Document 3.1 – ES Volume 2

Appendix 3.3: Response to PINS Scoping Opinion

Wheelabrator Kemsley (K3 Generating Station) and Wheelabrator Kemsley North
(WKN) Waste to Energy Facility DCO

Response to the Planning Inspectorate's Scoping Opinion

Drawing number - 1371 SK138

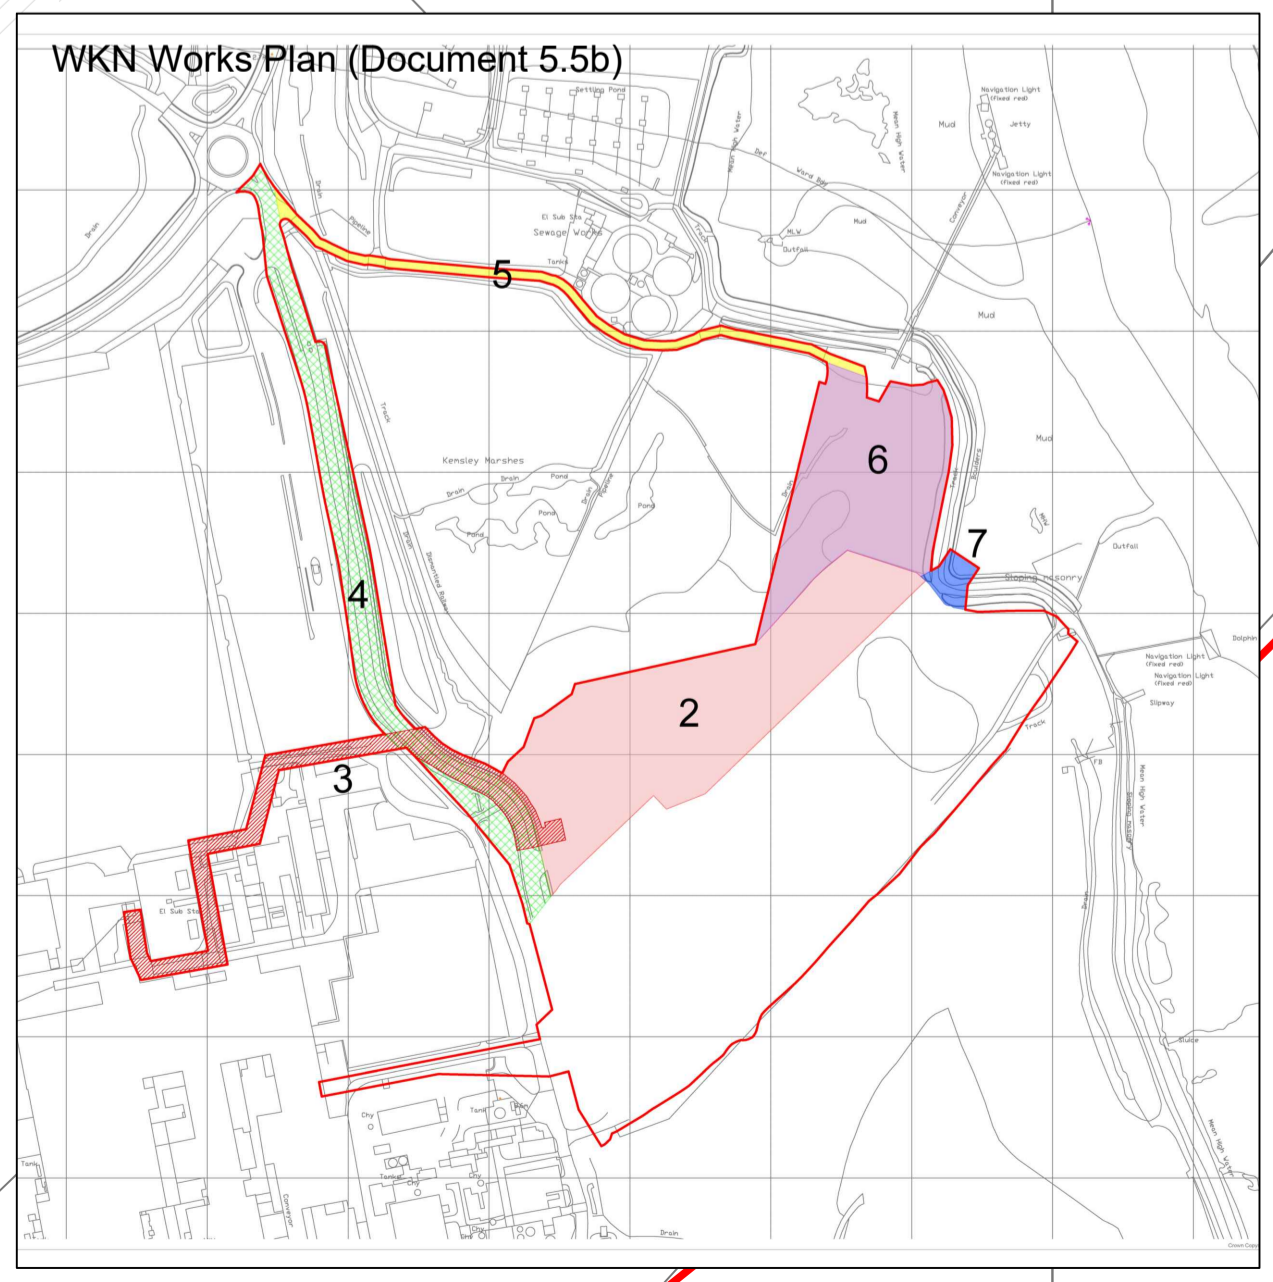
The description of WKN provided in the Scoping Report is limited in detail and no plans or diagrams are included. The Inspectorate notes that the design of the facility is not yet finalised and the dimensions of the structures, including the stack, are not yet confirmed. The Inspectorate expects that at the point when an application is made, the description of the proposed structures will be sufficiently developed to include the design, size and locations of the different elements of the Proposed Development. This should include the footprint and maximum heights of all proposed structures (relevant to existing ground levels) as well as land use requirements for all phases and elements of the development.

In particular, and to ensure a robust assessment of likely significant effects the ES should confirm the diameter and height of the stack and it should be clear what assumptions have been made regarding the placement of the stack, particularly with regards to air quality modelling and the landscape and visual assessment. The description should be supported (as necessary) with figures, cross-sections and drawings which should be clearly and appropriately referenced. Where flexibility is sought, the ES should clearly set out the design parameters that would apply, and how these have been used to inform an adequate assessment in the ES.

See Chapter 2 of the ES.

See Chapter 2 of the ES.
